25 July 2022

RE: Notice of Exhibition – New School - Minarah College (SSD 30759158)

**PROPERTY: 268-278 Catherine Fields Road, CATHERINE FIELD
LOT: 1001 DP: 1234527**

DRAWING ID: P2108320-PS01-R02-D100

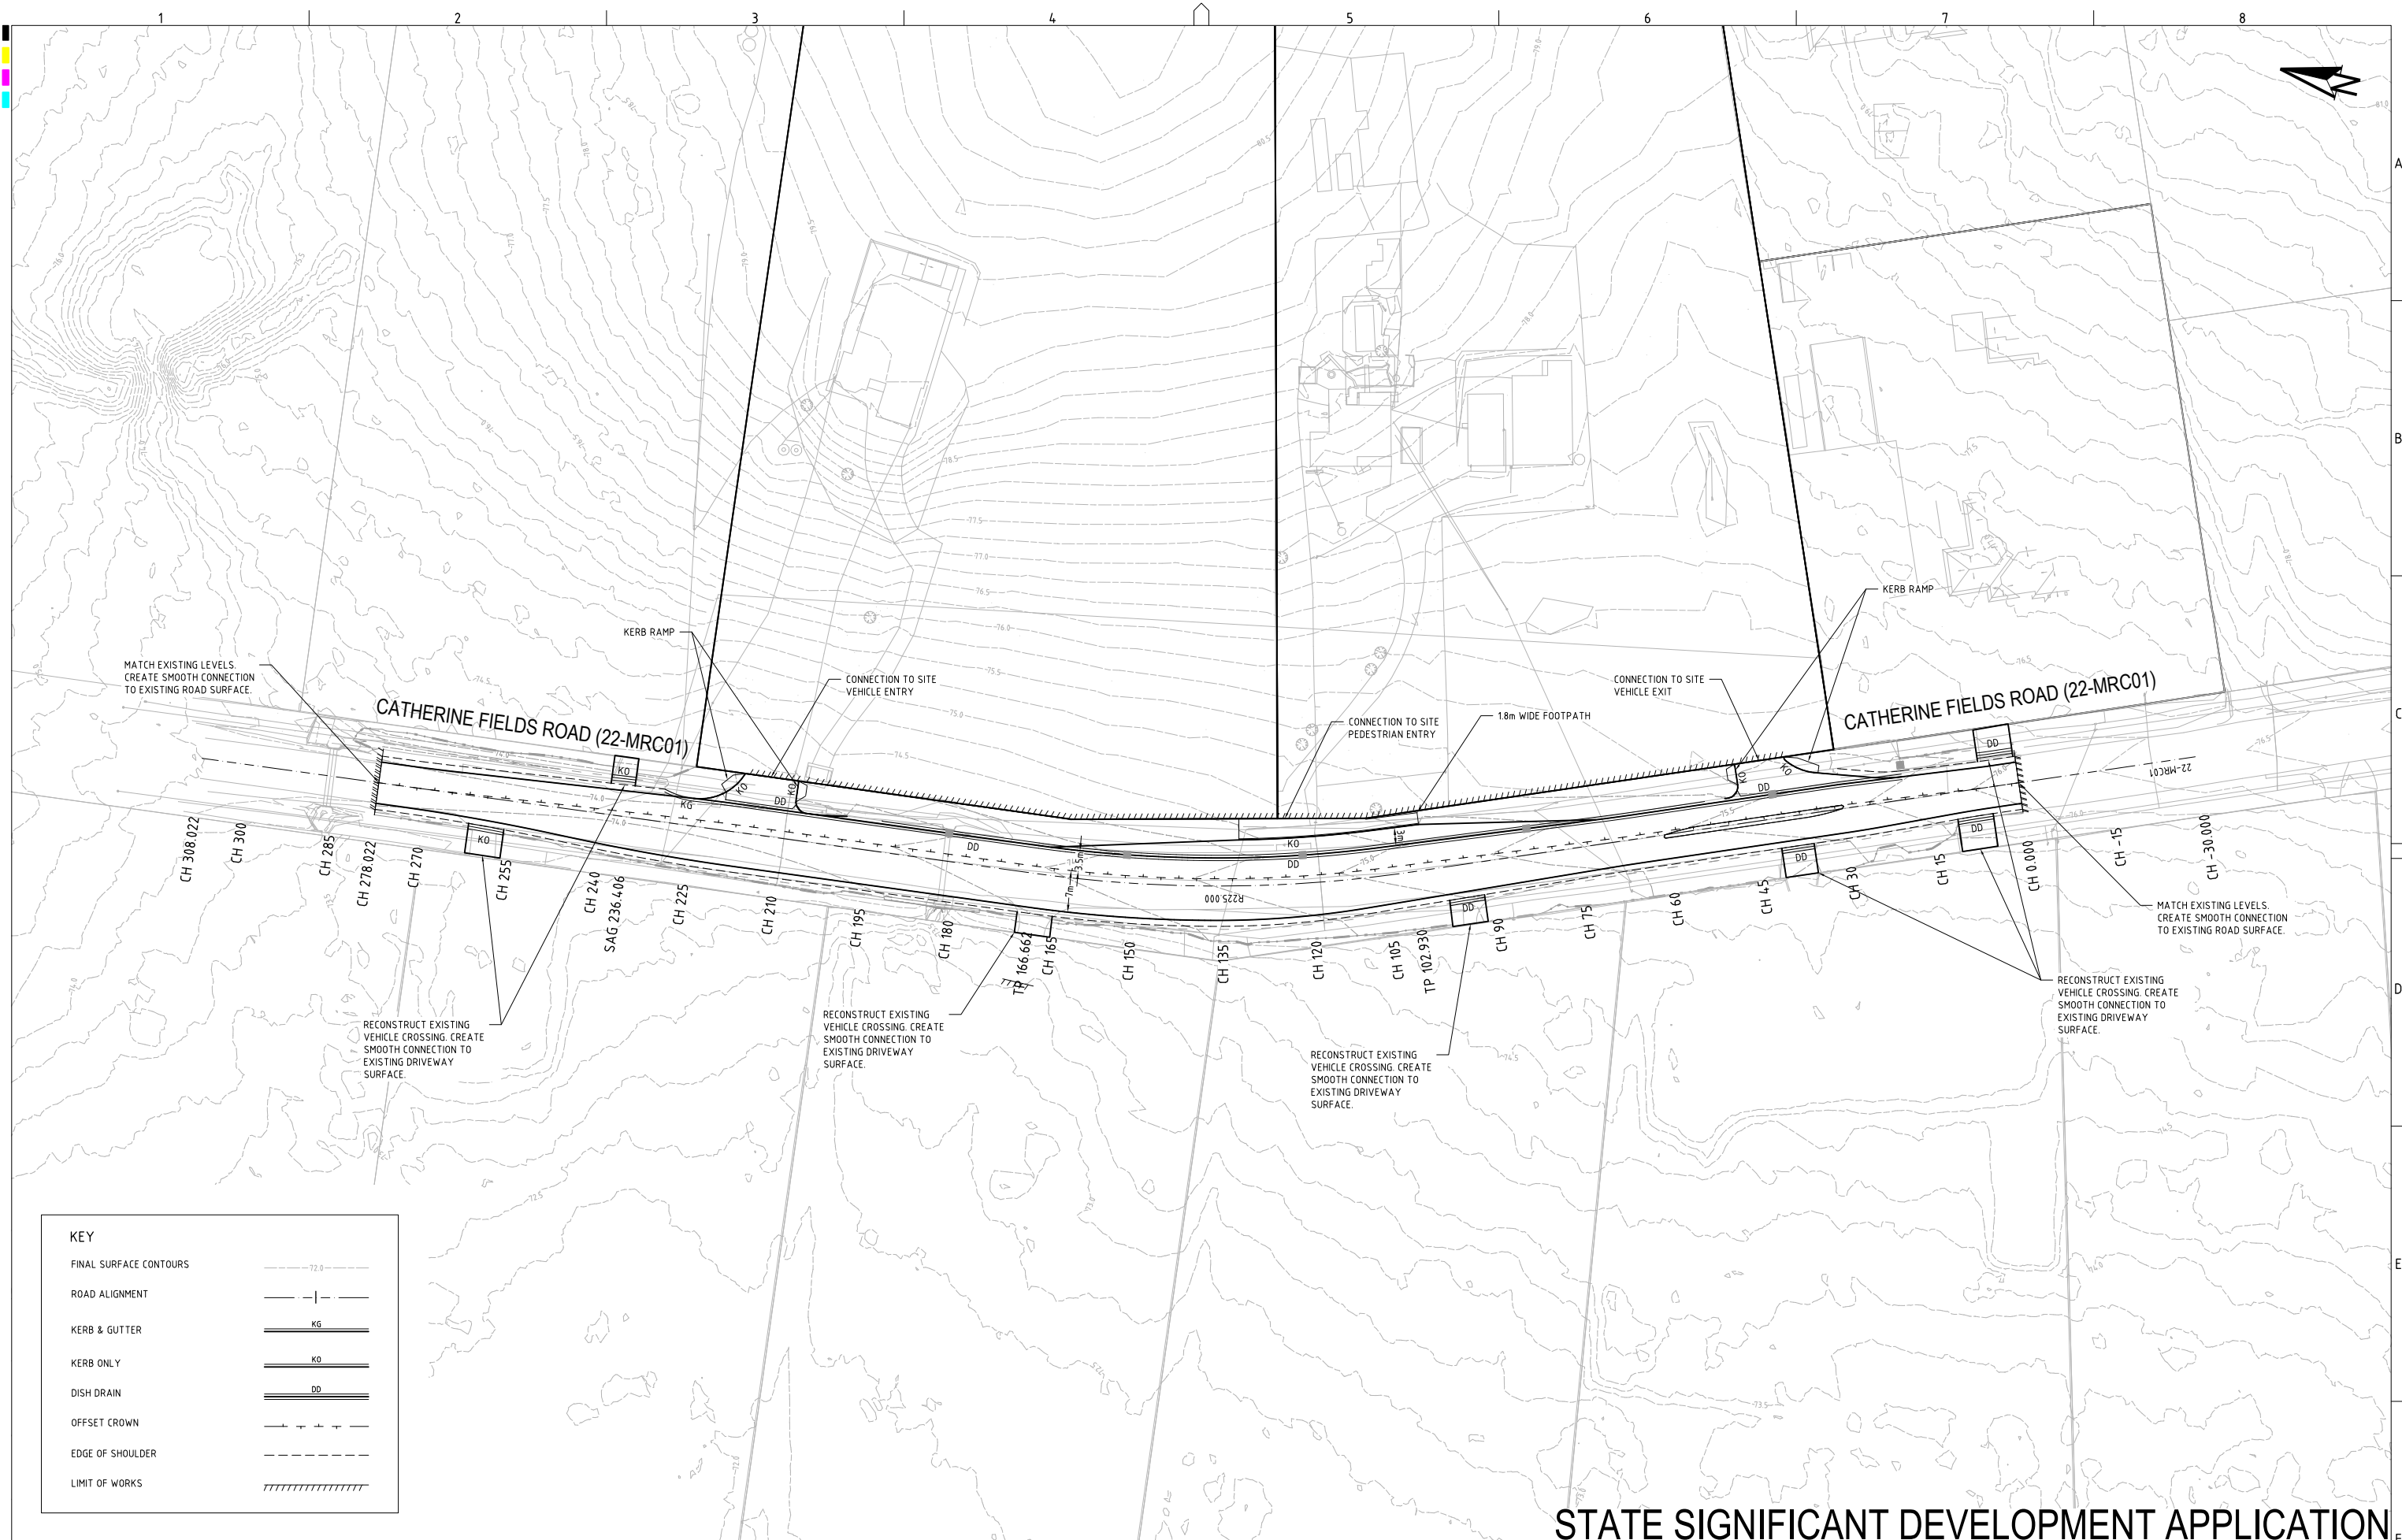
The staged road works in front of the school are not supported by Council. If the development is approved (despite the objections of Council), the road works, including channelised intersection and median, should be delivered with Stage 1 to reduce the impact on the community and to reduce the impact on school users who would be impacted by construction works later down the track when the future stage triggers their requirement.

The traffic report states that channelised right turn entry is not required until Stage 4. Council disagrees with this conclusion and if the application is approved Council requests that this be required as part of Stage 1.

BUS BAY INTERSECTION PLAN
AND SETOUT TABLE (22-MRK01)

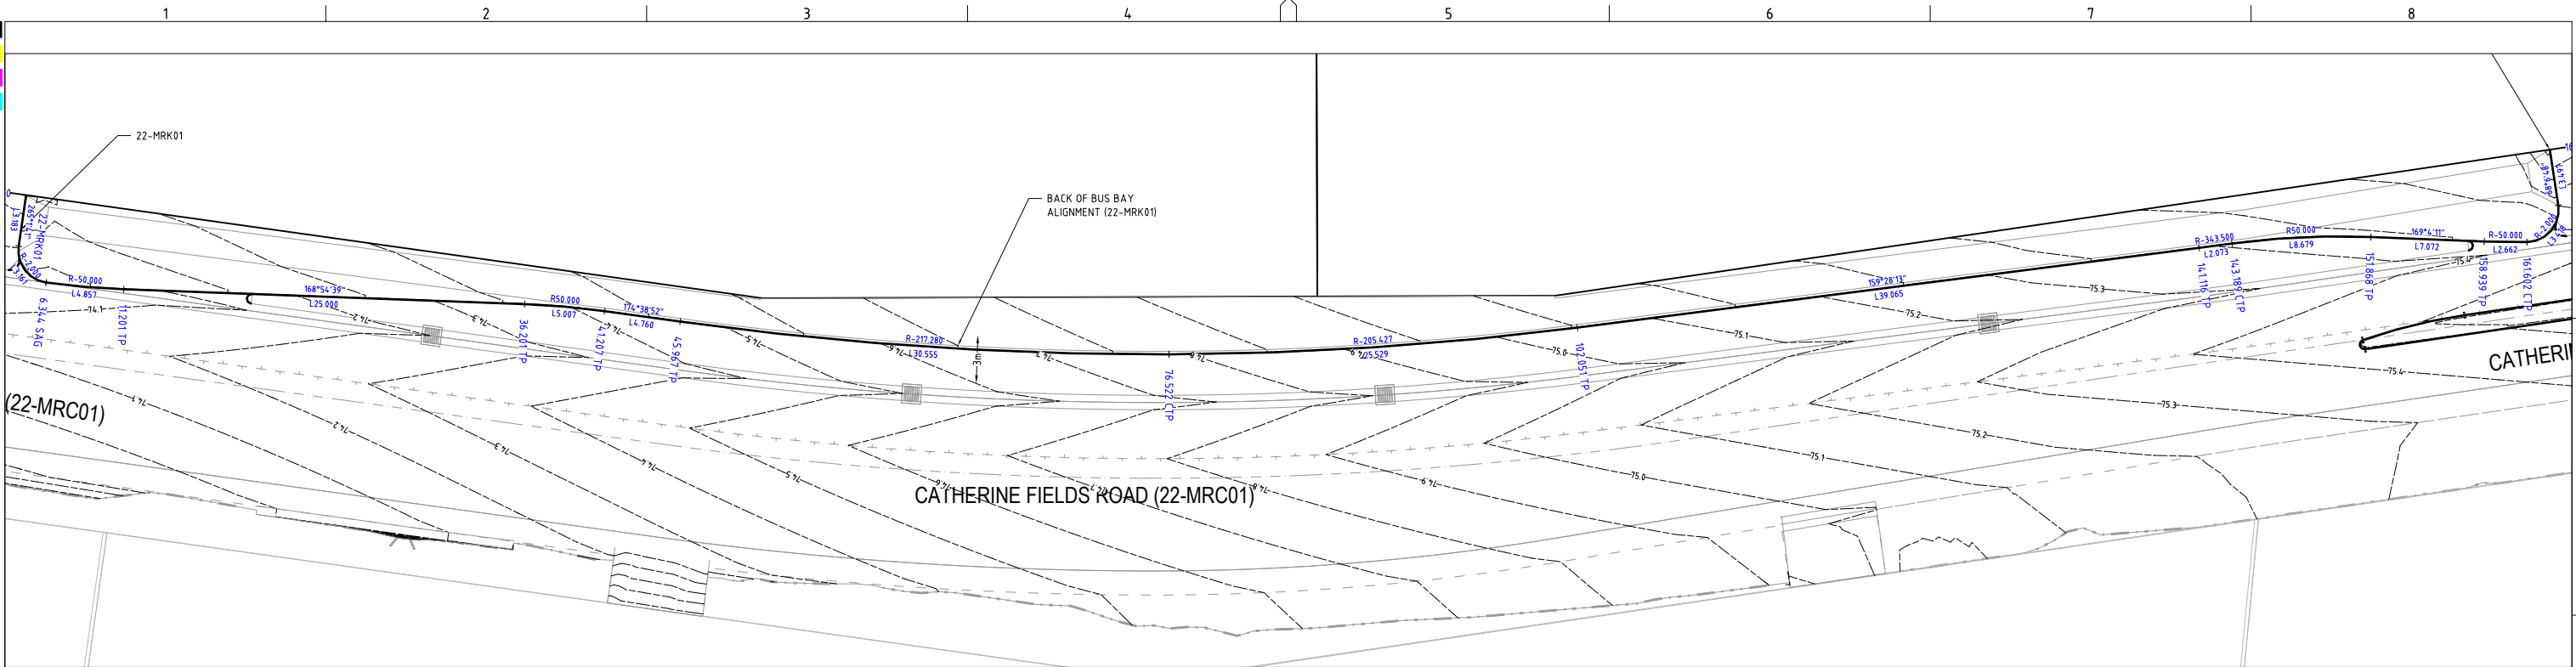
Indented bus bays are proposed on the eastern side of Catherine Fields Road at the western frontage of the school. A 1.8m wide footpath is proposed adjacent to the indented bus bay. Council has had to widen several paths surrounding schools to 3m as narrower paths proved insufficient to accommodate the needs of pedestrians. In some cases overflow onto roads has been observed. It is recommended that the footpath width be increased to 3m.
